**CITY OF PORTLAND, MAINE
DEVELOPMENT REVIEW APPLICATION
PLANNING DEPARTMENT PROCESSING FORM
DRC Copy**

2010-0031
Application I. D. Number
9/14/2010
Application Date
New Single Family
Project Name/Description

PROJECT NAME: 67 Douglass street

From: Shukria Wiar
To: NYR4ever@maine.rr.com
Date: 10/13/2010 1:27 PM
Subject: 67 Douglass Street Single Family application

DATE: 09/02/2010 PILE# 210159
 SCALE: 1" = 20'

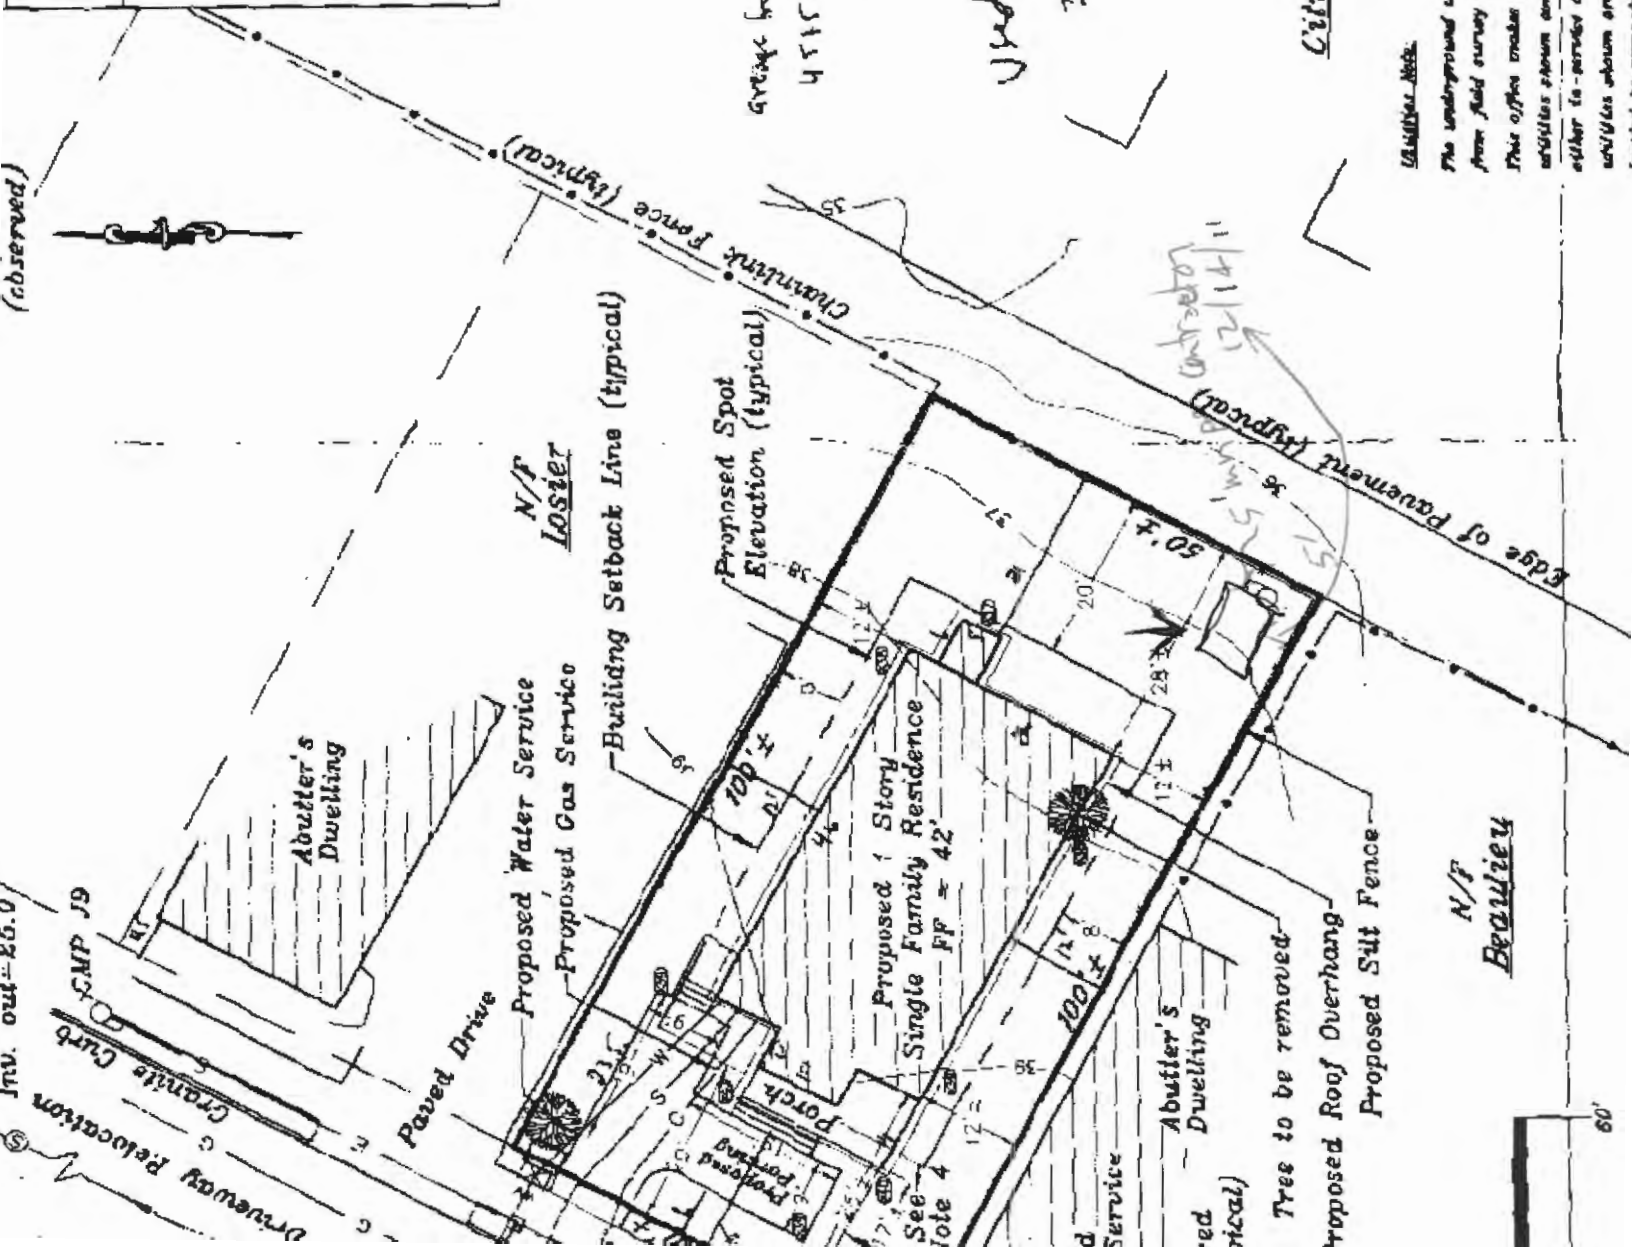
1. A boundary survey must be submitted for a review; the survey must include the following standards:

2. As proposed stormwater seems to drain onto the school property; the city does not have issues with the back portion of the property draining into the school property but requires the front portion of the parcel drain into the street. Please revise site plan to show this requirement.

- 01 The applicant shall close the existing curb cut, as shown on site plan and boundrary Survey dated 09/02/2010.

- 01 The site shall be graded as such that the front portion of the parcel shall drain to Douglass Street and the back of the parcel shall drain to the City's property.
